CITY OF ALBUQUERQUE

November 4, 2005

**Re: ARMC Site Renovations, Intersection of Walter Drive / Martin Luther
King Jr. Avenue, Grading and Drainage Plan
Engineer's Stamp dated 10-28-05 (K15-D6G)**

SHEET TITLE:
OVERALL SITE
GRADING PLAN

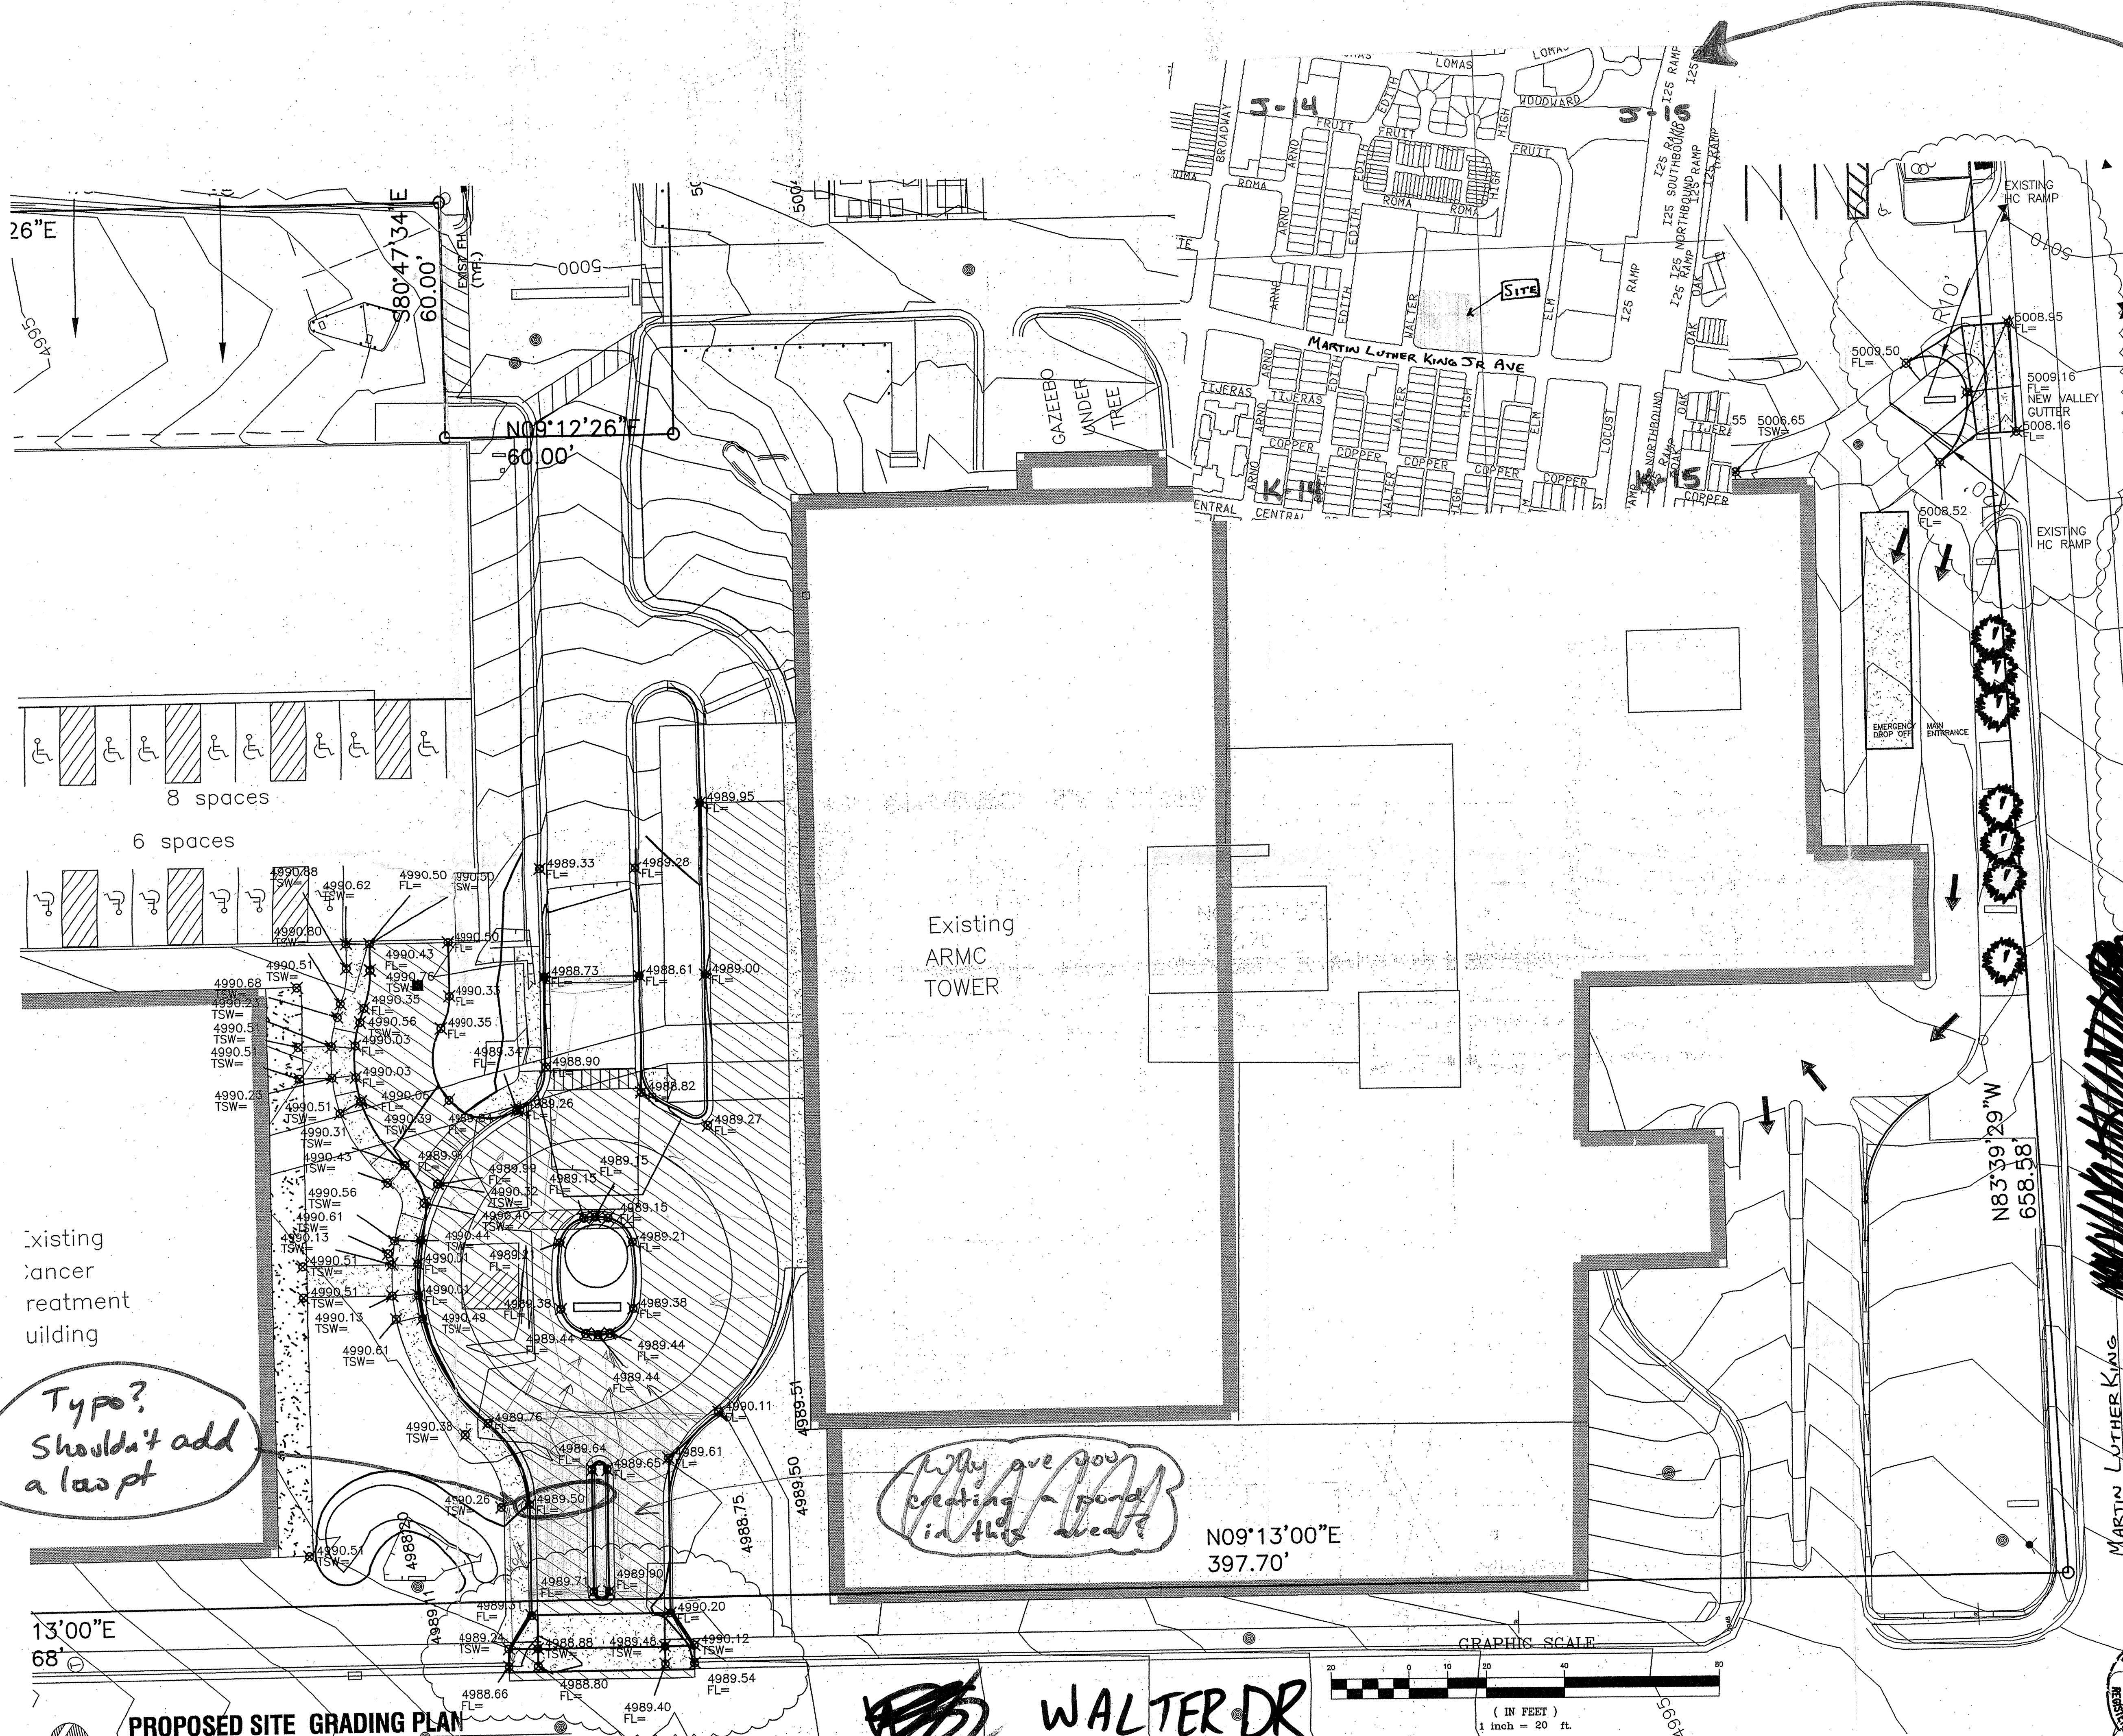
Based upon the information provided in your submittal received 10-31-05, the above referenced plan is approved for Paving Permit and Grading Permit. However, please note that the flow line elevation shown approximately 40 feet east of Walter Drive would create a low point. Please correct this elevation. Upon completion of the project, please provide an Engineer Certification for our files.
